OXFORDSHIRE COUNTY COUNCIL'S RESPONSE TO CONSULTATION ON THE FOLLOWING DEVELOPMENT PROPOSAL

Application no: 13/01394/F

Proposal: Erection of 32 dwellings and associated car parking, landscaping and infrastructure

Location: Land East Of Heyford Leys And Blds 400 500 And 400 To 410 UH12 And UH13
Camp Road Upper Heyford

HEYF-5-SK206 C

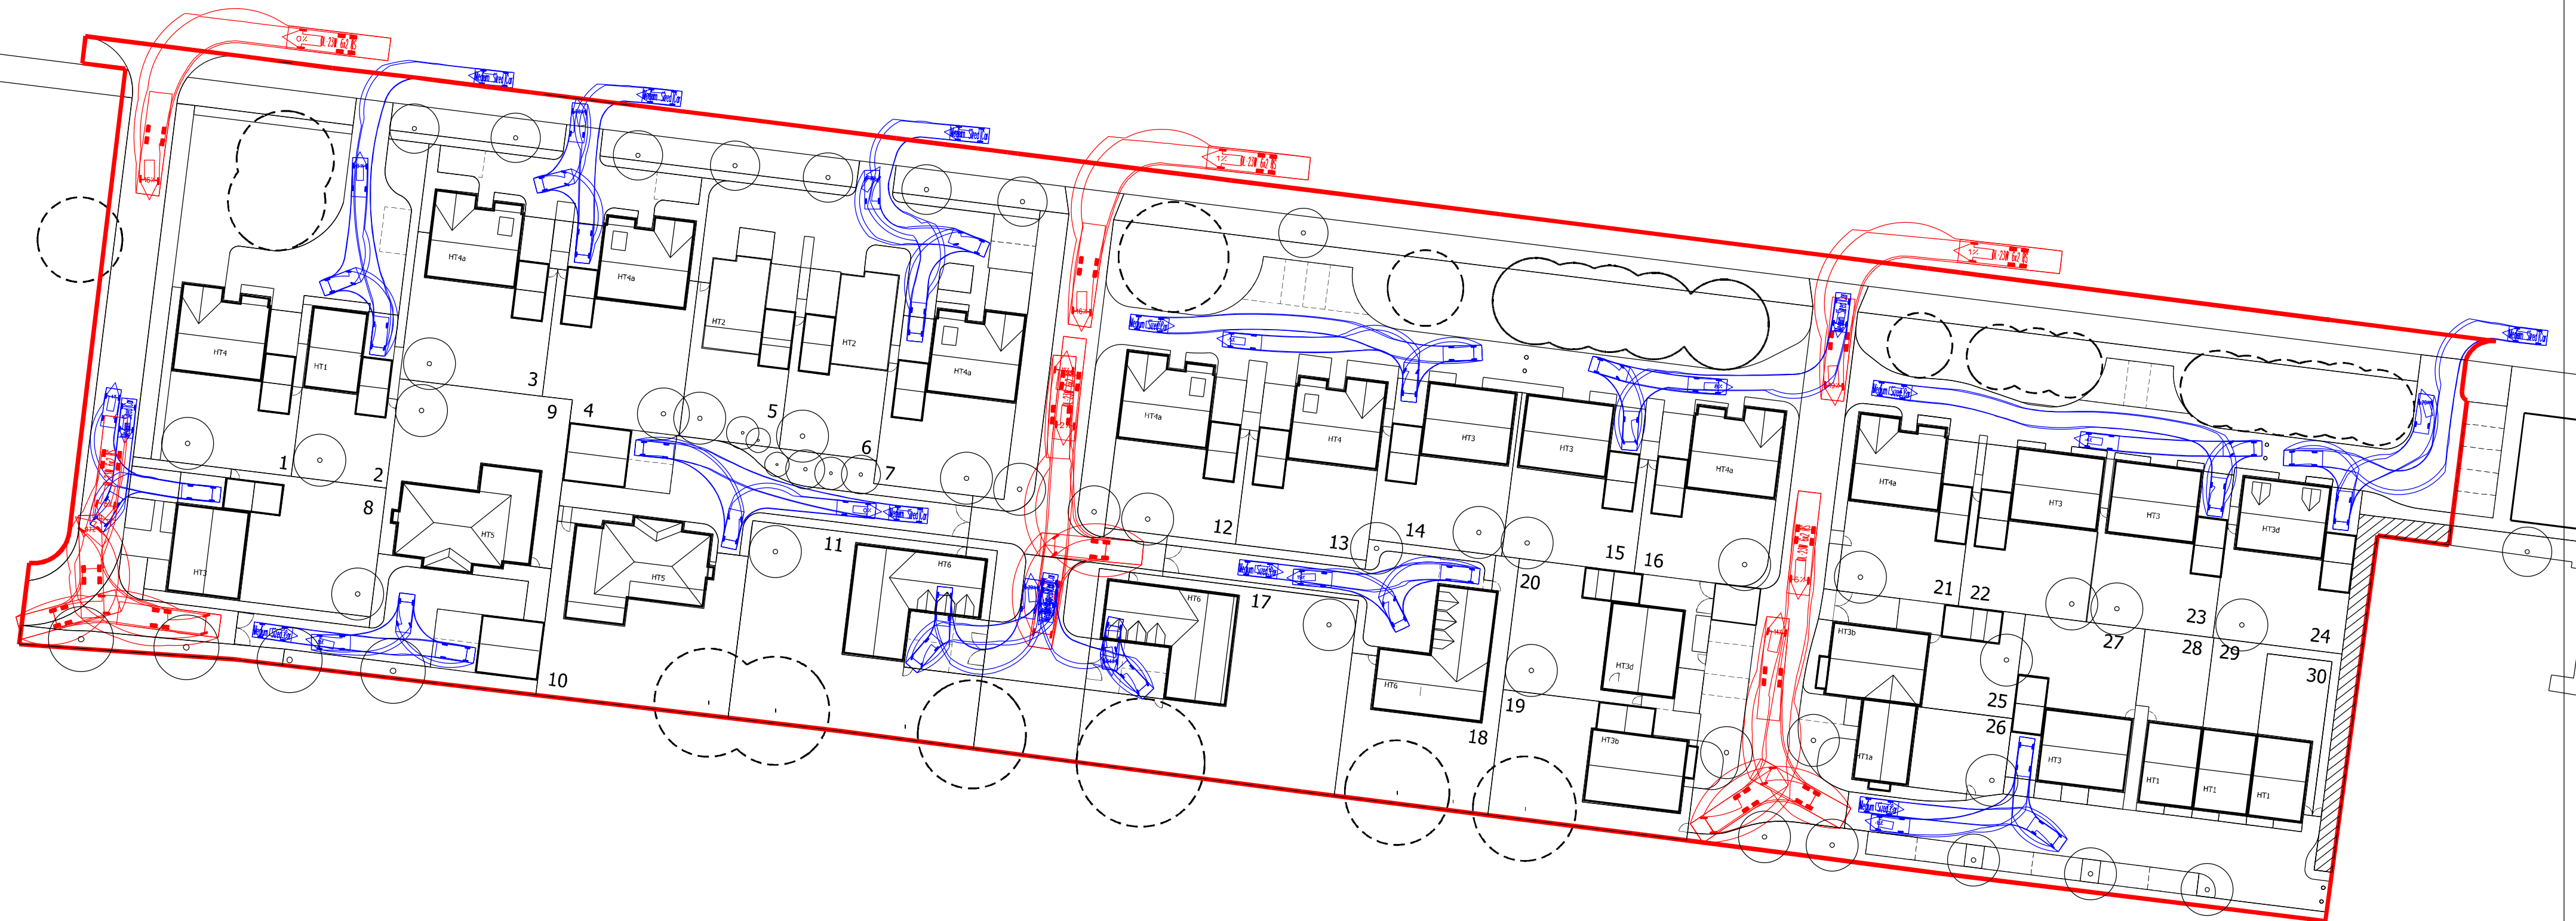
- Tracking of refuse vehicles within the proposed development is not clearly demonstrated on an appropriately scaled plan and appears impractical. This information must be revised and submitted on a larger scale plan. The proposed estate layout may need to be subsequently amended.
- The number of parking spaces indicated on plans (75 spaces) does not match that on application form (95 spaces). The proposed car parking levels do not meet the necessary standards. Such an under-provision of car parking is likely to lead to overspill parking and subsequent highway safety and maintenance issues in the vicinity.
- Details of visibility splays at the new access points onto the highway have not been demonstrated on plans, and safe highway accesses have not therefore been confirmed.
- Revised information is requested to address the above concerns.
